TfNSW Reference: SYD20/01213/03 Departments Reference: SSD-10101987

EXHIBITION OF EIS - KEMPS CREEK DATA CENTRE - 709-769 MAMRE ROAD, KEMPS CREEK

Attachment A

Job No	Drawing No	Issue
277863-00	SKT002	E

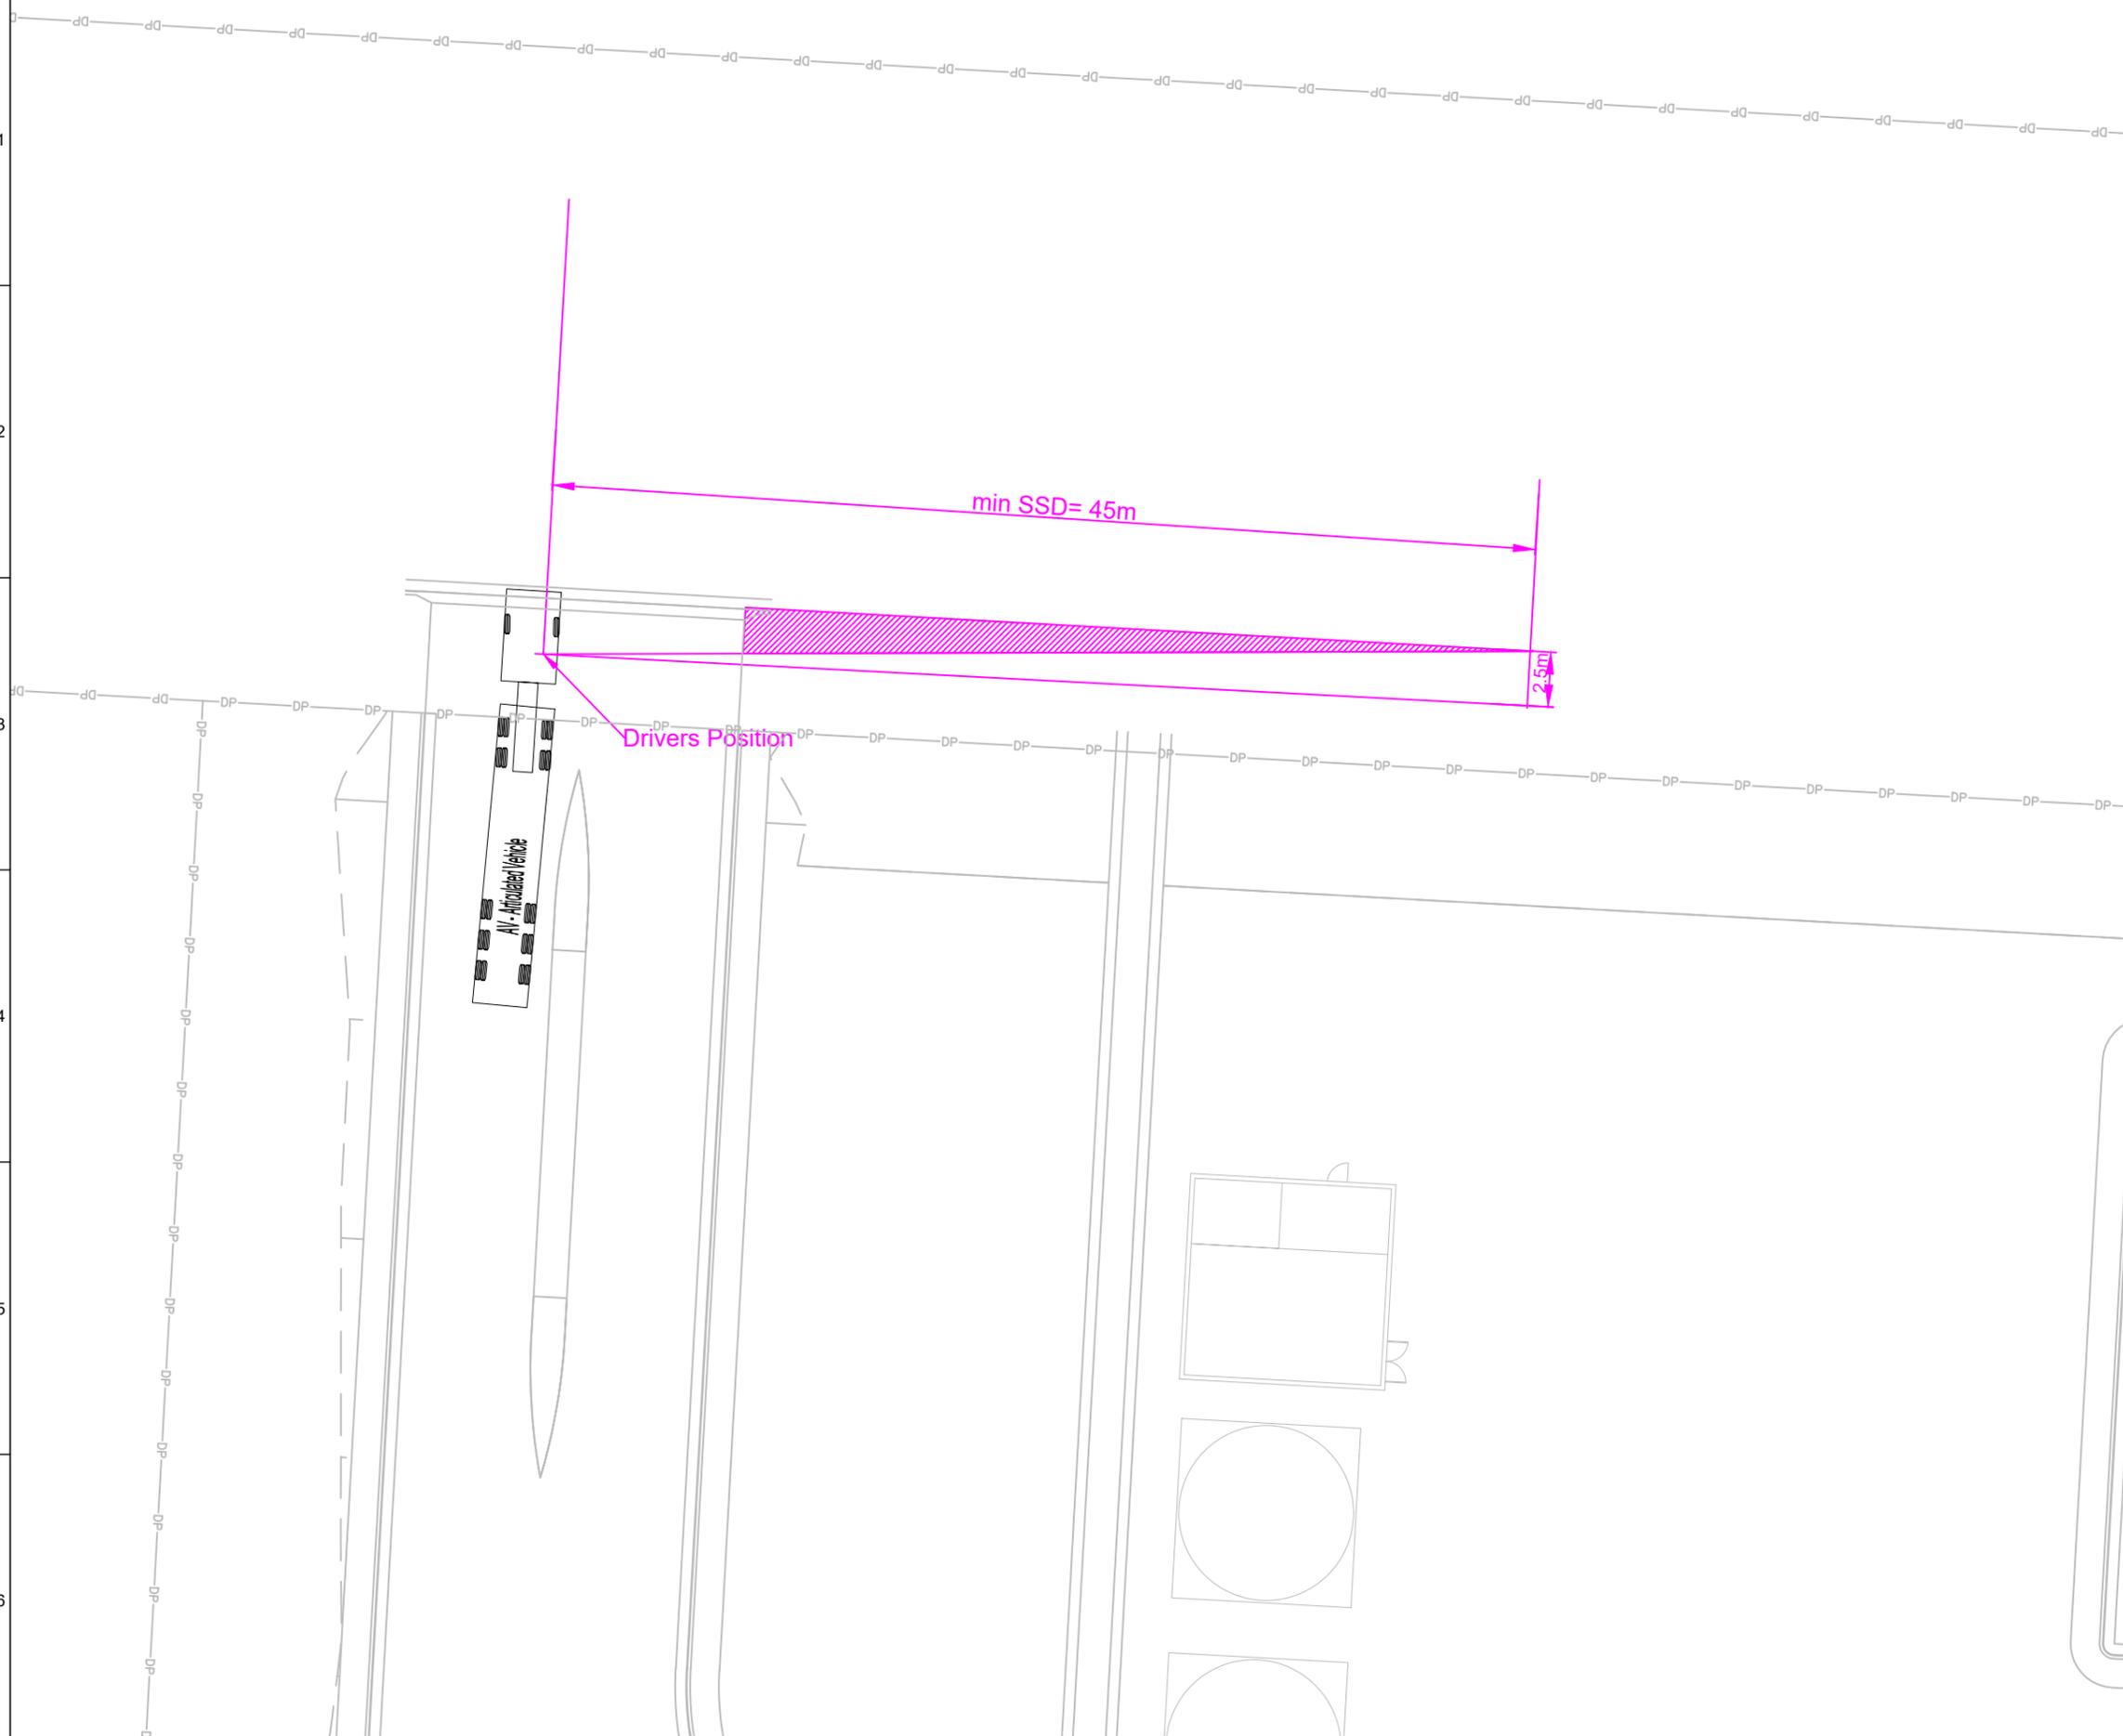
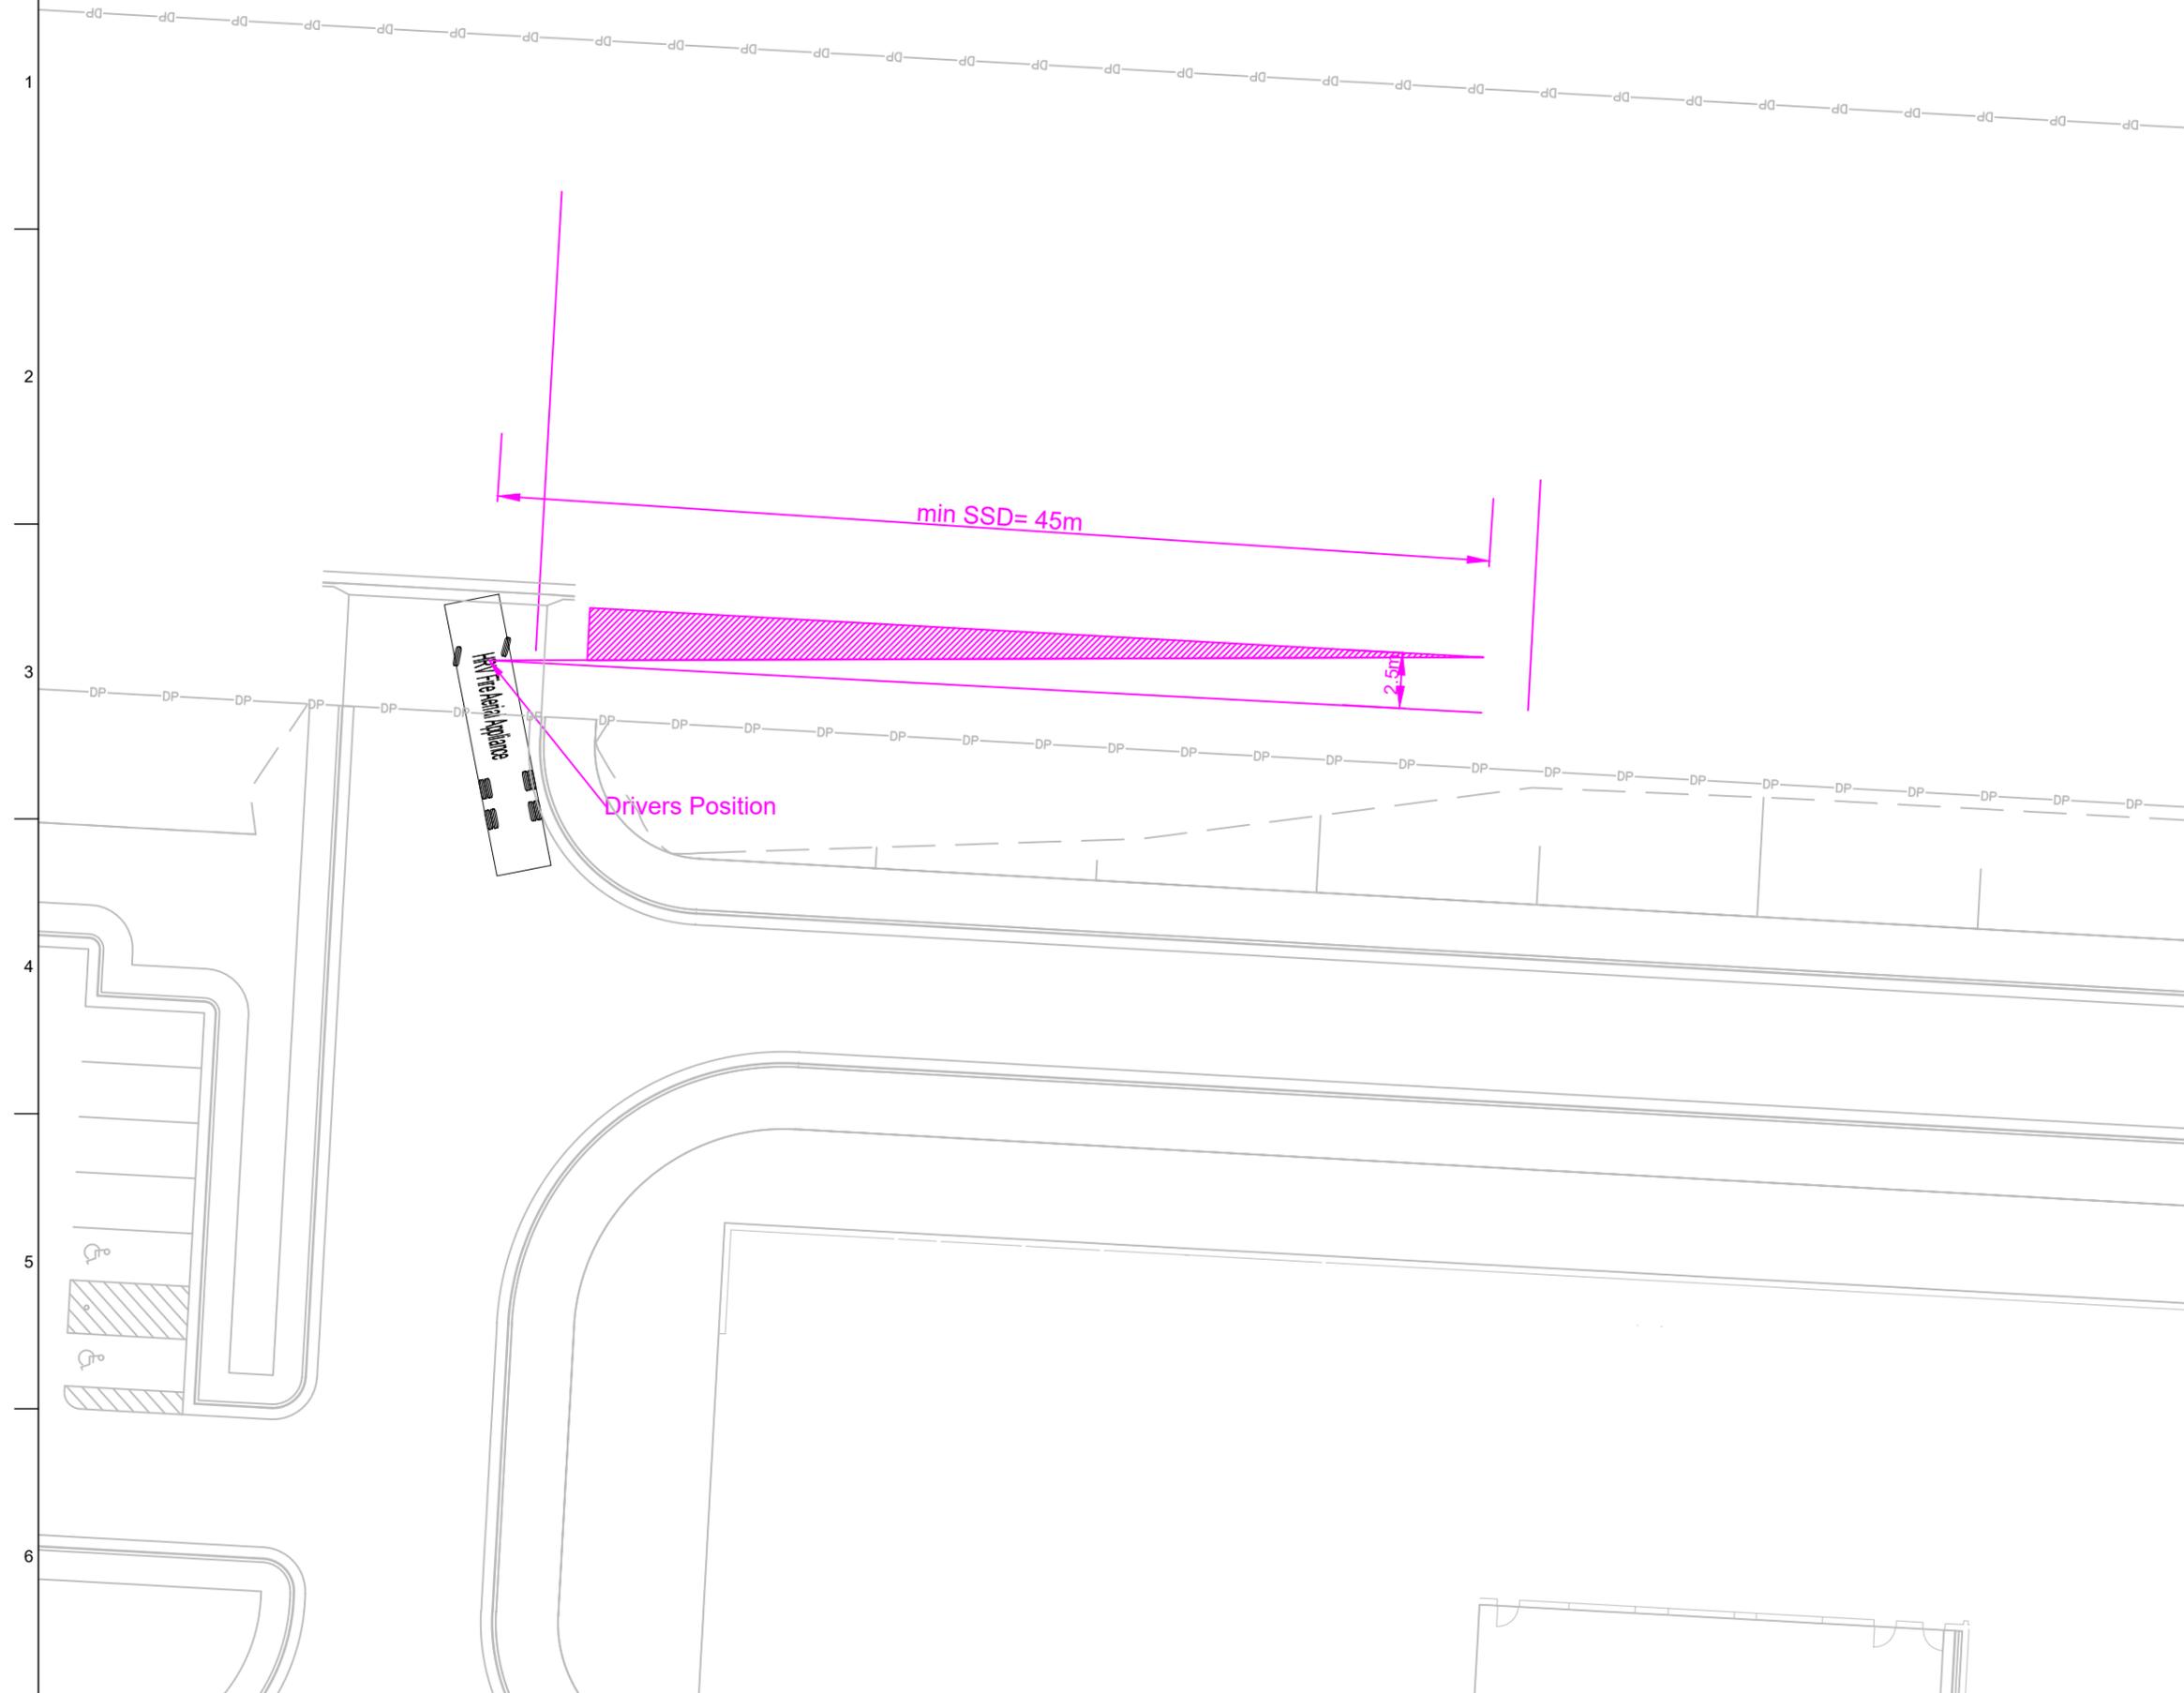
Appendix B – *Technical Drawings* – The swept path plans are provided for a 19 metres Articulated Vehicle. However as mentioned above, according to the Mamre Road Precinct DCP Table 13, it should be tested for 30m PBS Level 2 Type B vehicle.

It is recommended that the swept path plans be provided to reflect the Mamre Road Precinct DCP requirements.
